# Rezoning Transportation Analysis

Petition Number: 2022-133

## Revision Log:

Date	Description
1-25-23	First Review (TM)

# RZ-1.0

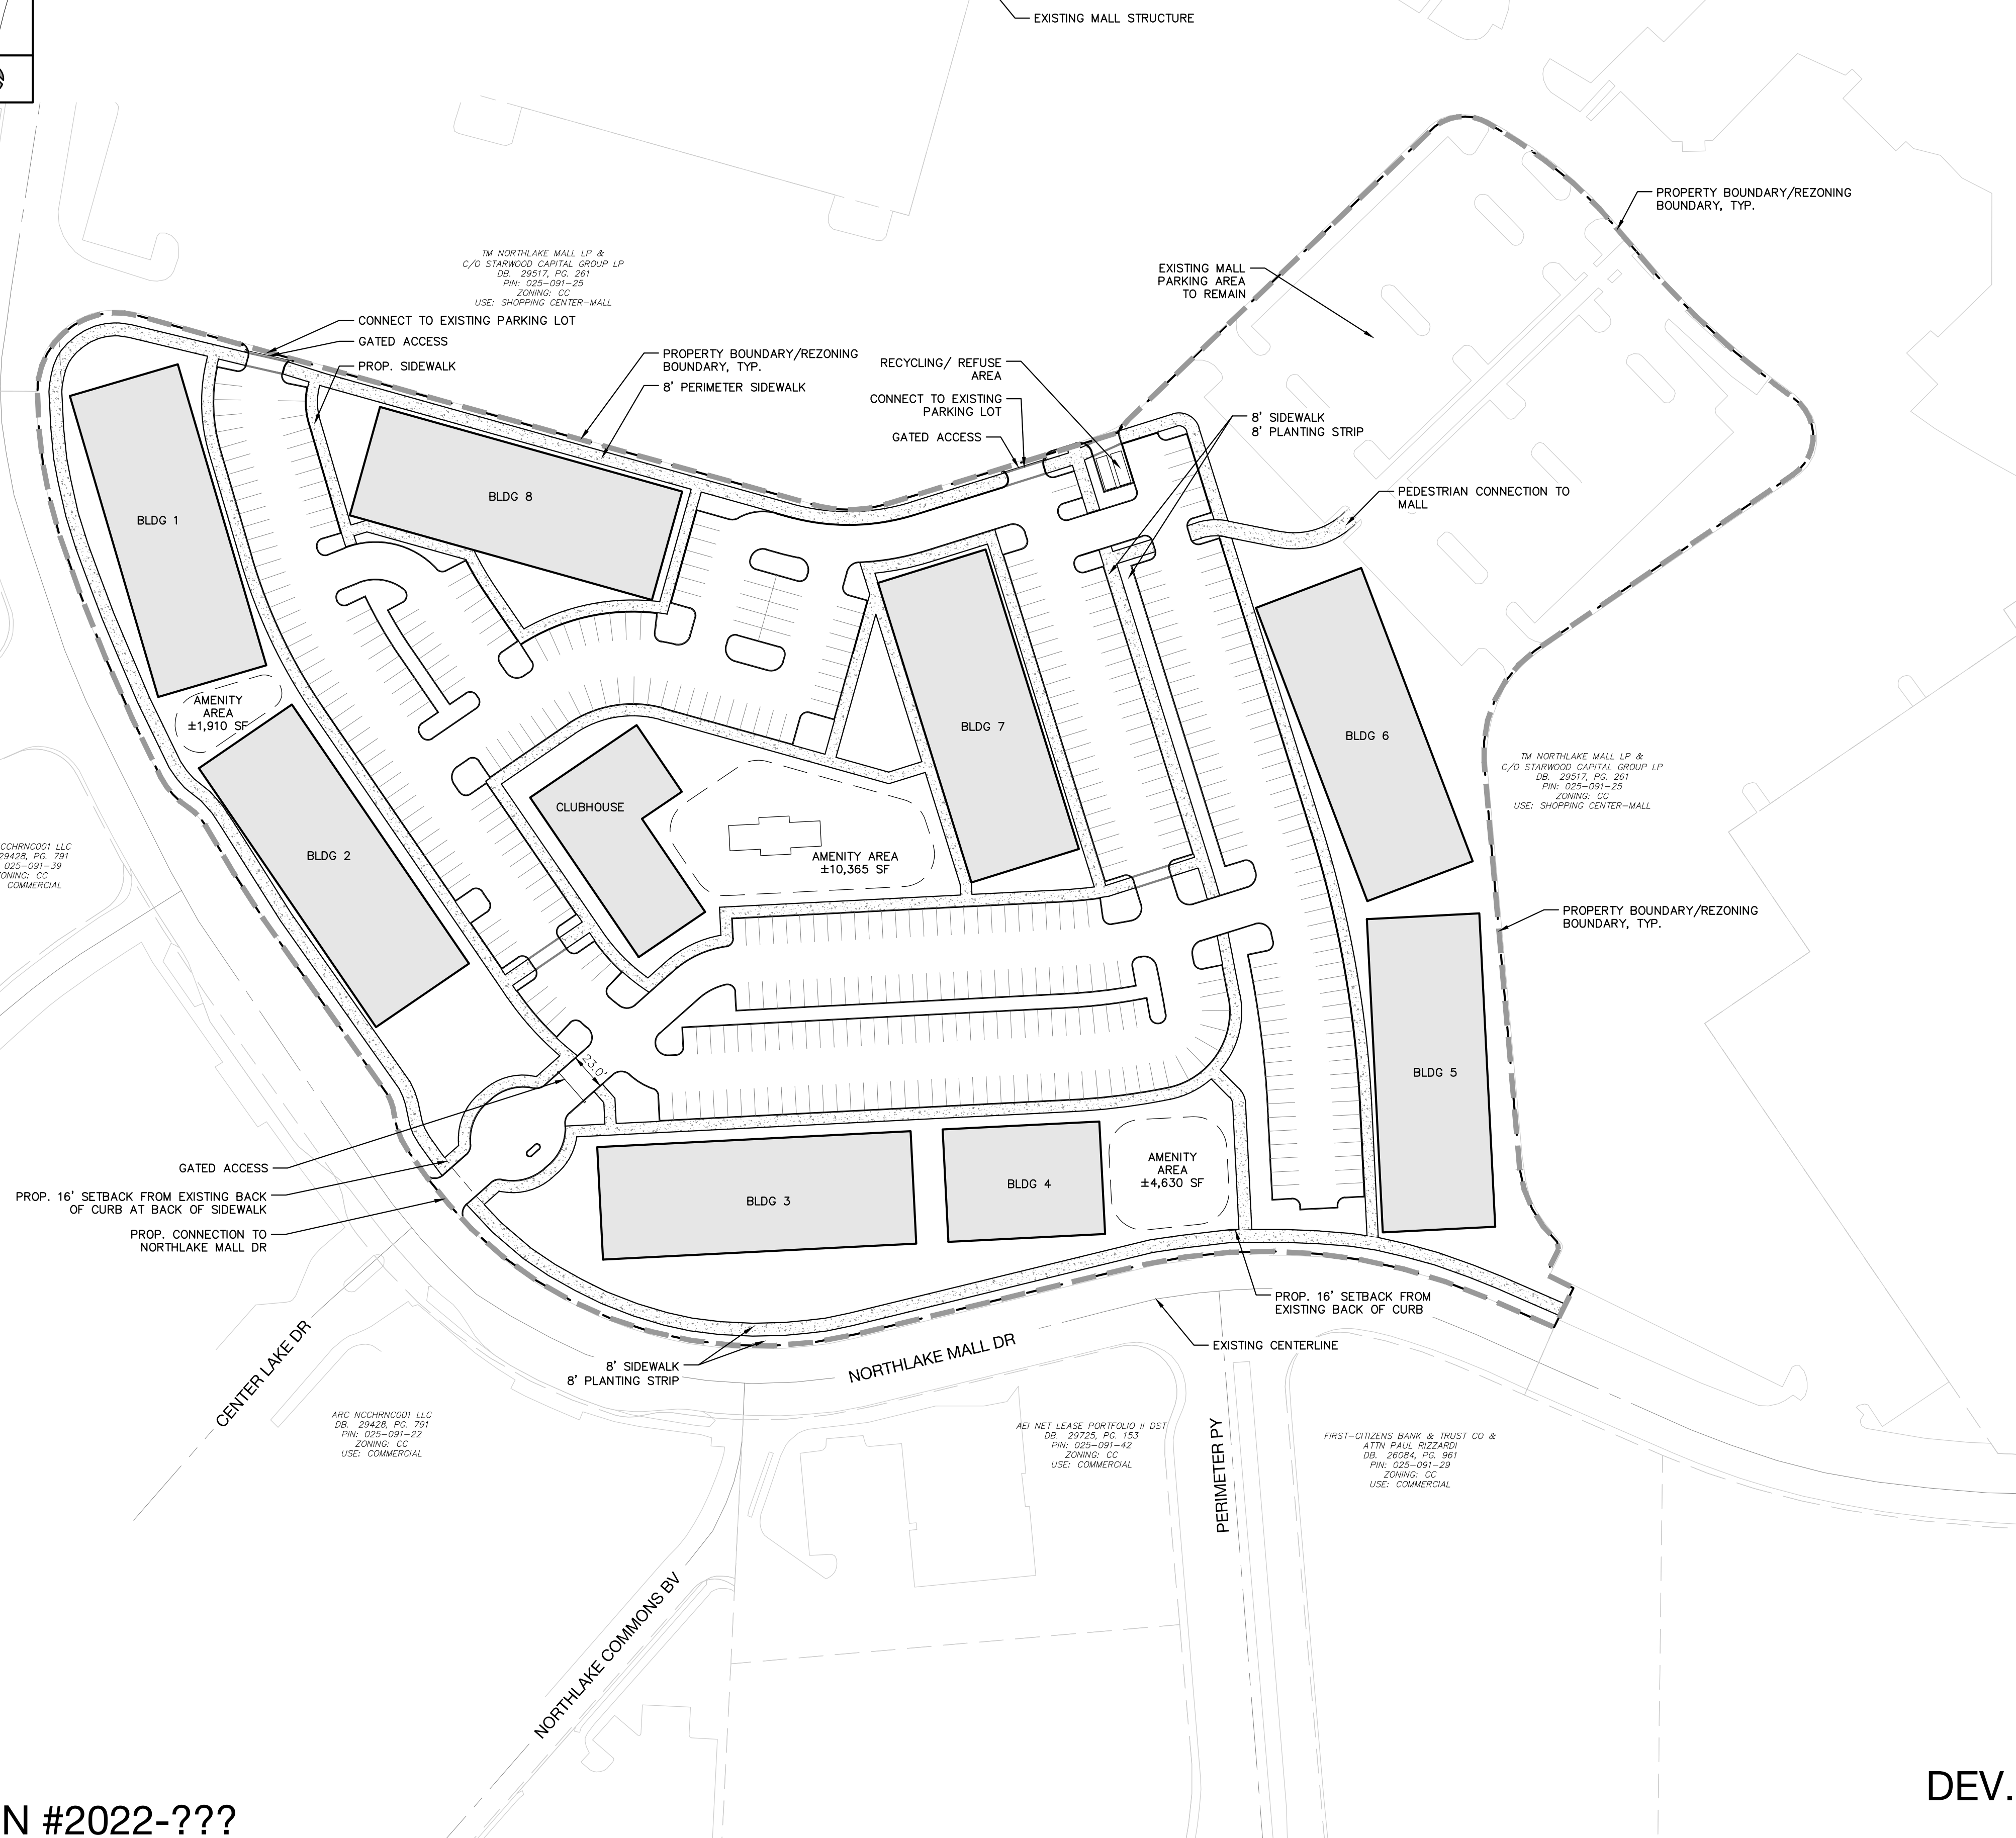
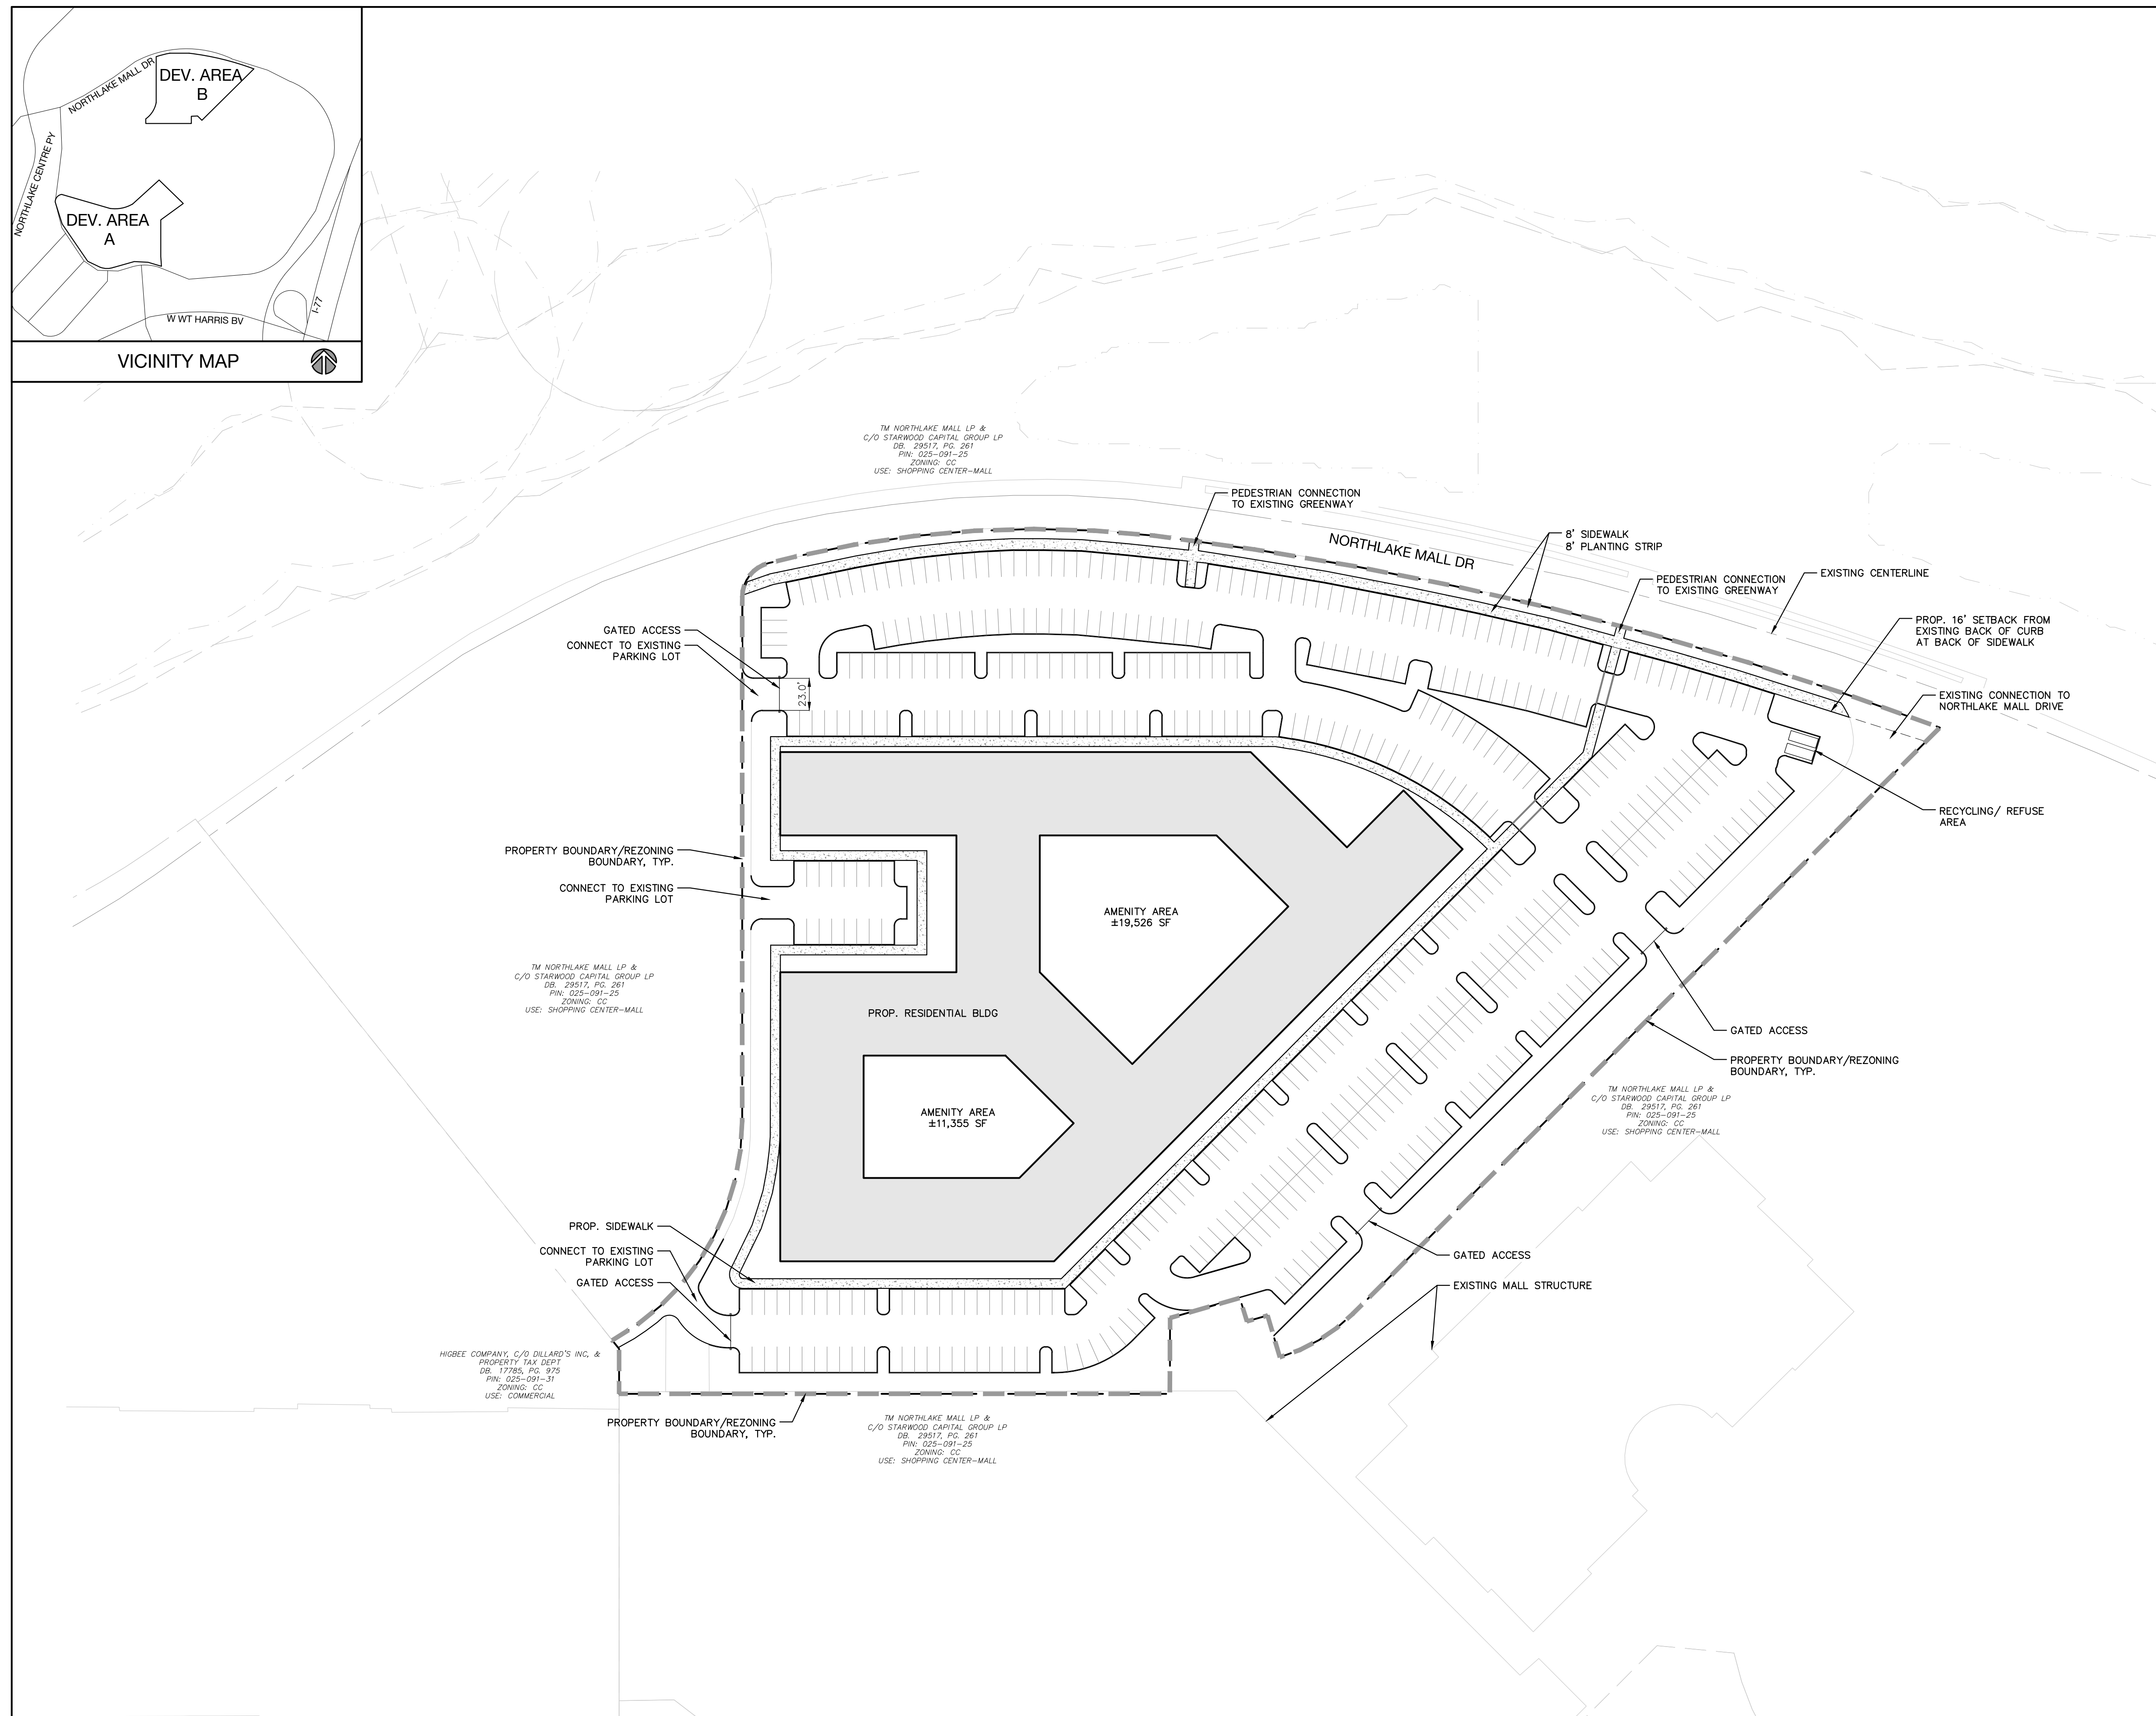
4. Revise conditional note(s) by removing all references to other rezonings and filling in rezoning information in the notes.

Not rezoning  
frontage

Fill out info

**REZONING PETITION #2022-???**
